**2024/1078**

**Description:** Single storey rear extension to single storey detached dwelling

South Elevation

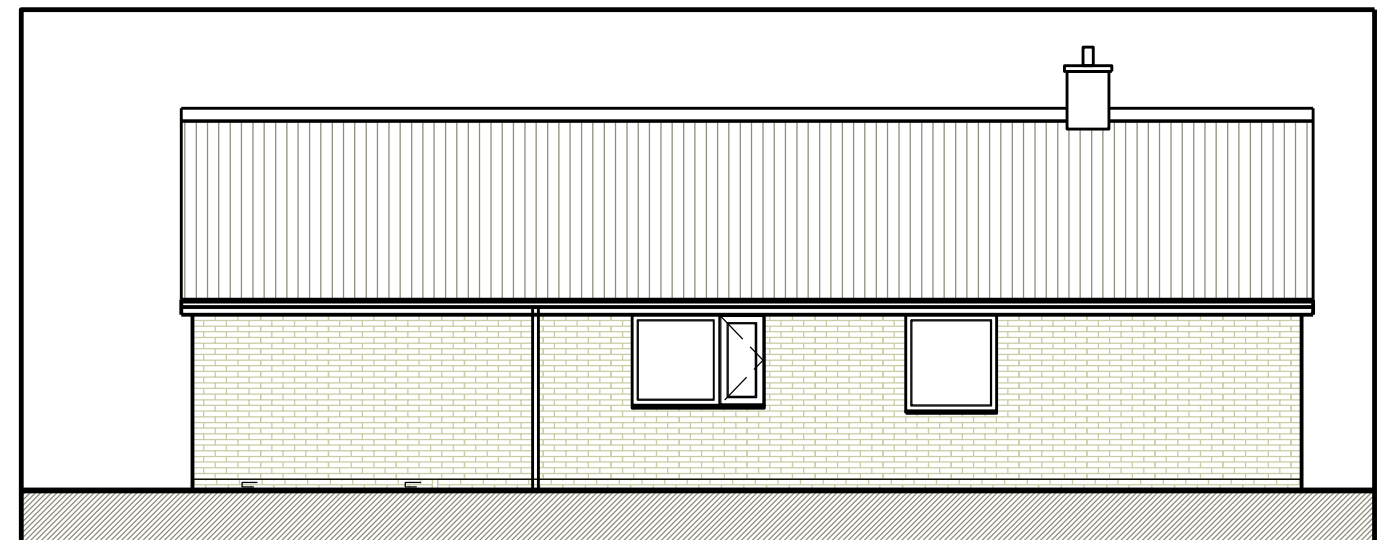
All existing roof and eaves heights have been checked on the existing plans and remain unaltered on the proposed plans, with the extension matching the existing dwelling. There is a slight visual discrepancy regarding the length of the proposed south side elevation. This is presumably an IT error which has been unable to be resolved in amended plans, but correct measurements have been confirmed by the applicant's representative.

Site Plans - PROPOSED

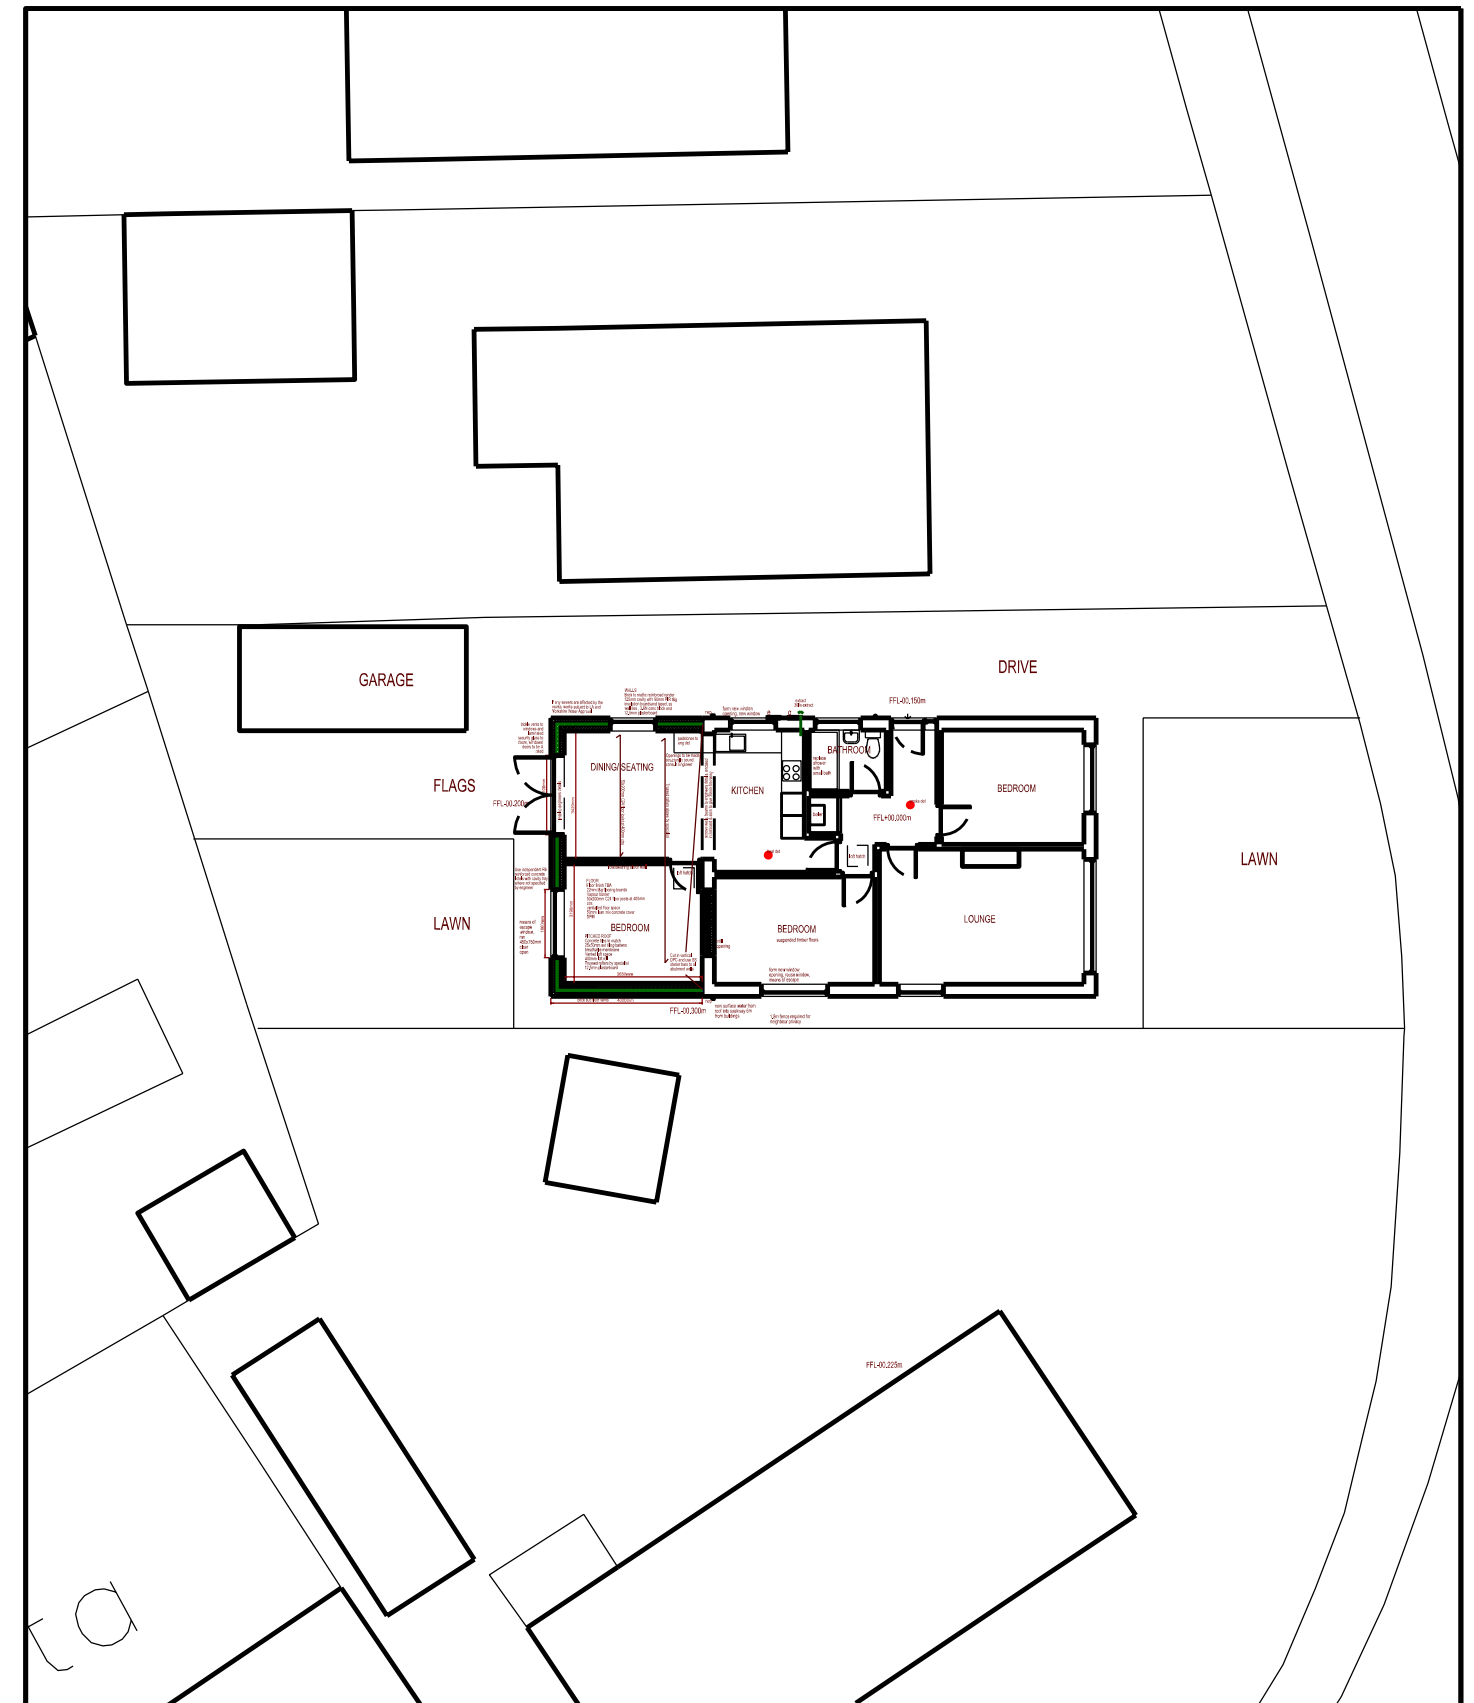
The proposal is close to the boundary with No.20, but the extension would be located near a reasonably high fence and be a good distance away from the neighbouring dwelling to create any significant impact on their amenity. The extension is located more than 7m from the rear boundary, which is also a strong boundary consisting of a large hedge and the blank elevation of a neighboring outbuilding.

Regarding the neighbour at No.16, with a greater distance to the boundary and an existing garage between the proposed extension and the neighbouring garden, any impact on amenity would be insignificant.

Drawing Title: Floor Plan & Elevations - PROPOSED

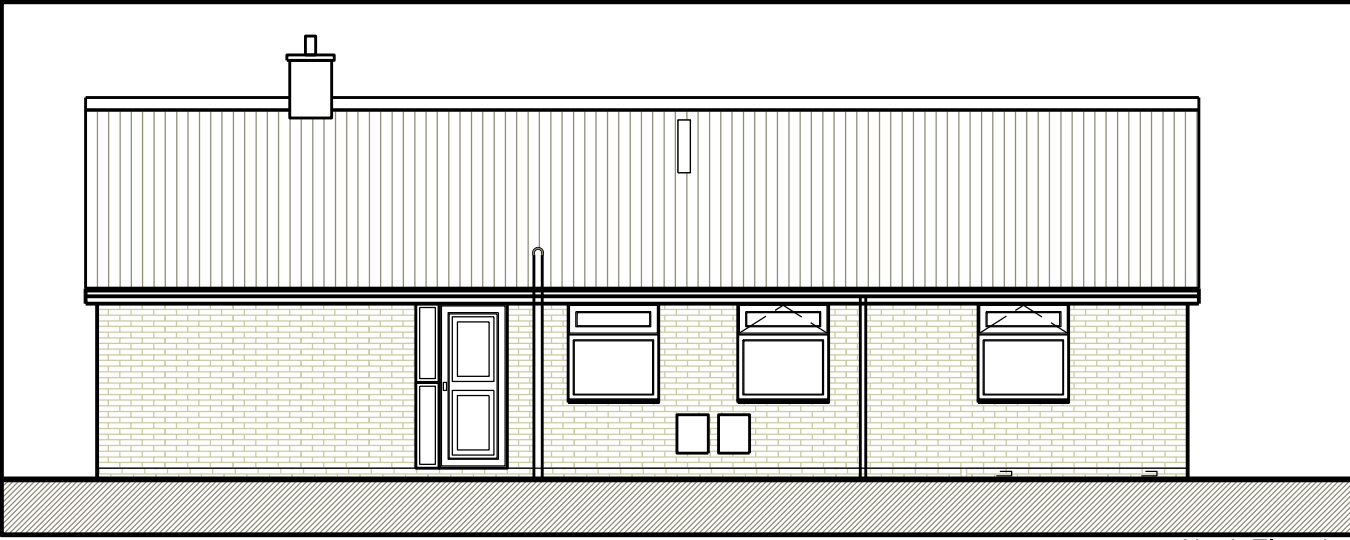
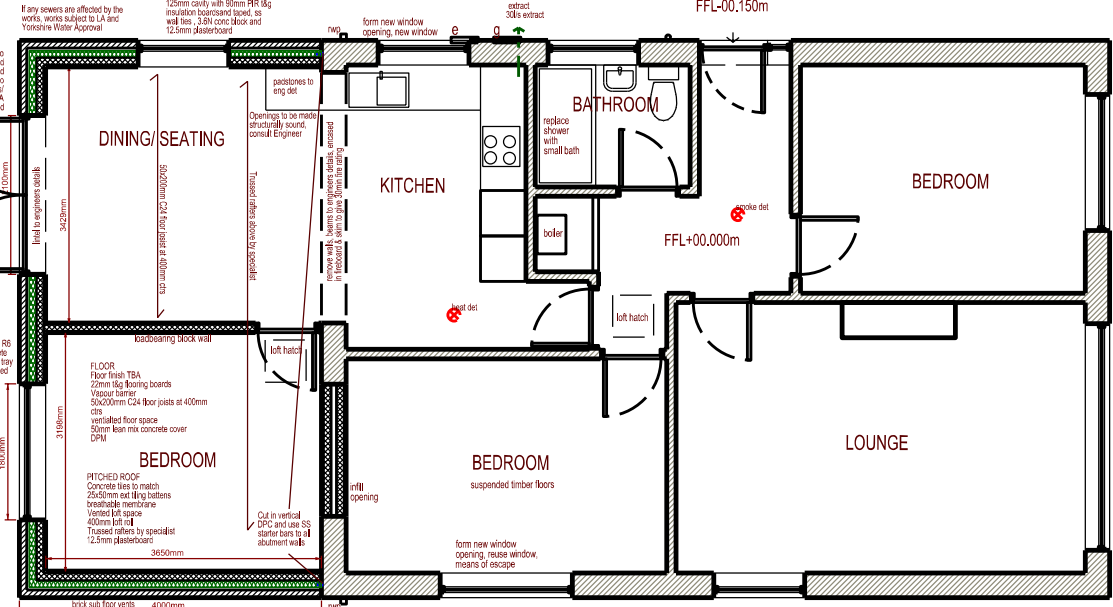
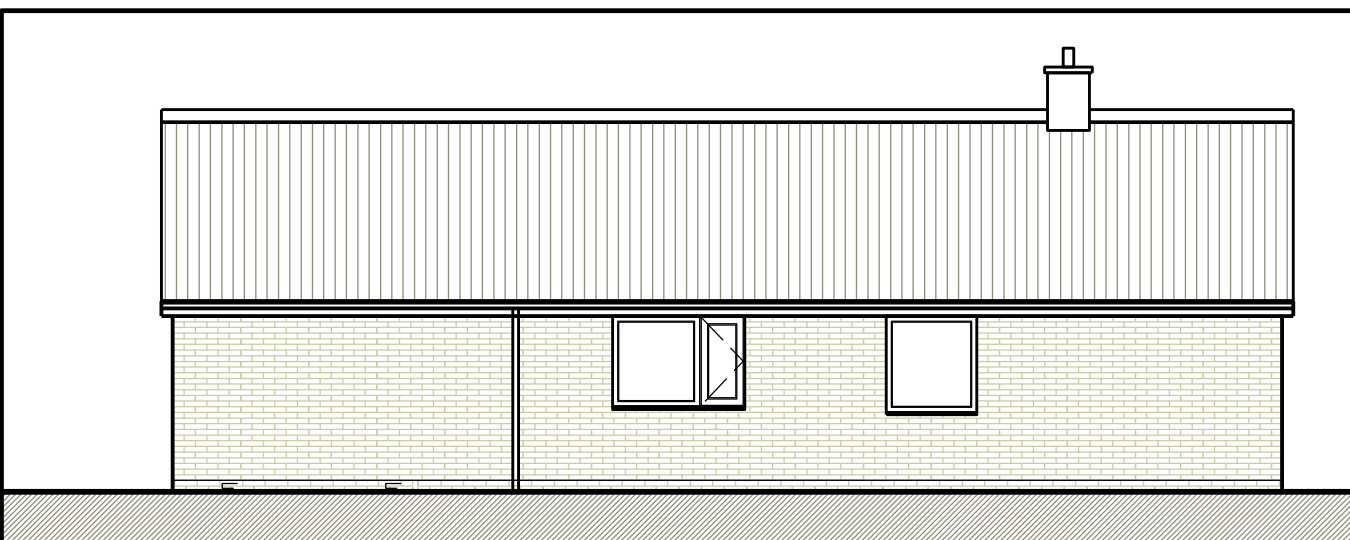
The 45-degree rule in relation to the extension and outlook from neighbouring windows would not be infringed. The proposed windows on the side elevation overlook No.16 would look at the blank elevation of No.16, and a narrow pathway between the No.16's elevation and the boundary, which is currently used for bin storage by one of the dwellings. The extra window on the original side

elevation overlooking the blank side elevation and side garden of No.20 would be allowed through permitted development.
